Planning Application Ref: AW/368/21/T

Location: 102 Rose Green Road, Bognor Regis, PO21 3EF

Description of works: 1no. oak tree - crown lift to 4m and reduce height to 10-12m and spread to 7-8m

THE OAK
IN QUESTION

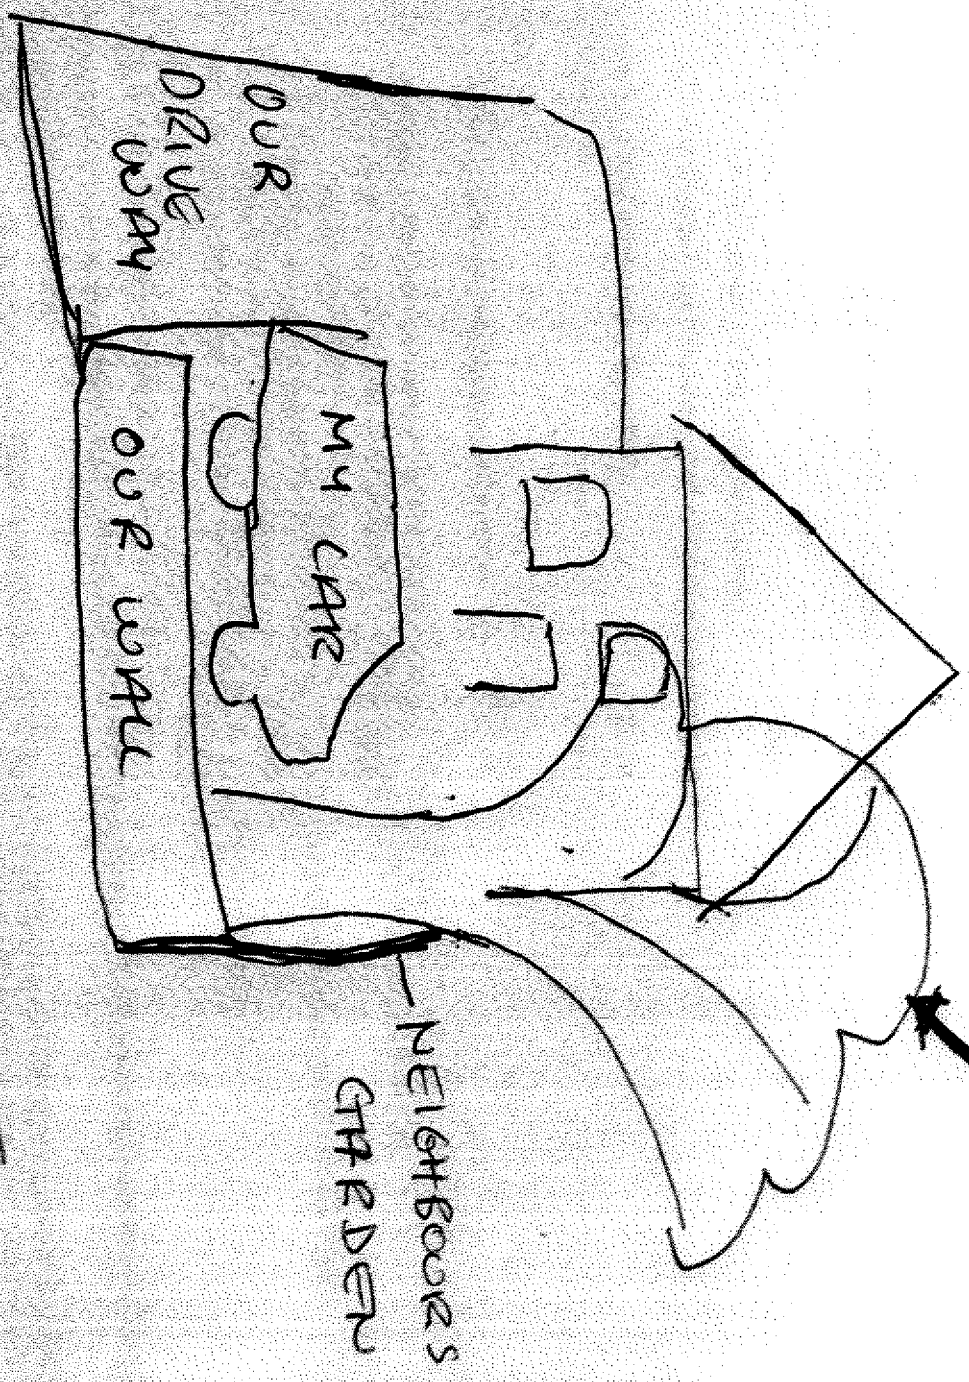
- Outwardly and from a distance (roadside) this tree appears to be in a fine physiological state and assumed to be so in the absence of any evidence provided to the contrary.
- It is a prominent tree with an attractive crown profile, although formed upon a complex limb and branch framework. Height reduction pruning has occurred within the last 10 years, with 1-2 metres of regrowth. Large upswept limbs on SW and NE aspects limit potential for reduction of lateral spread – that will need to be minimal and carefully undertaken so as not to harm aesthetic value.
- The removal of low branches (*crown lifting*) to achieve 4m clearance above ground level on all aspects is not justified on arboricultural grounds and exceeds that which is recommended in the British Standard (BS3998:2010) Tree work.

- This tree requires careful management that respects its age and vulnerability to environmental changes and disease progression.
- It is a large tree with a complex crown and in proximity to a dwelling. It also possesses high public amenity value and so any approved work specification needs to be carefully worded to ensure reasonable management objectives can be met without damaging its profile.

- As it stands, I am unable to recommend approval for this application.
- **I would like the applicant to be invited to agree to a revised proposal for lesser works (as described below) as part of the current application so as not to incur delay.** Such work would go some way to addressing their concerns whilst preventing a diminution of the tree's landscape and public amenity value:

- i) *Crown lift on all aspects to provide a maximum of 2.5 metres overhead clearance.*
 - ii) *Reduce/remove selected small diameter (<50mm) branches to achieve a maximum of 2 metres clearance from dwelling and car port roof.*

- iii) *Reduce top height of tree by maximum of 2 metres, with respect to established 'knuckles' so as not to extend beyond the point of origin. Lateral spread to be reduced where required to balance crown profile and to leave a minimum of 5 metres radial extent on all aspects, attending only to small diameter (<50mm) branches.*
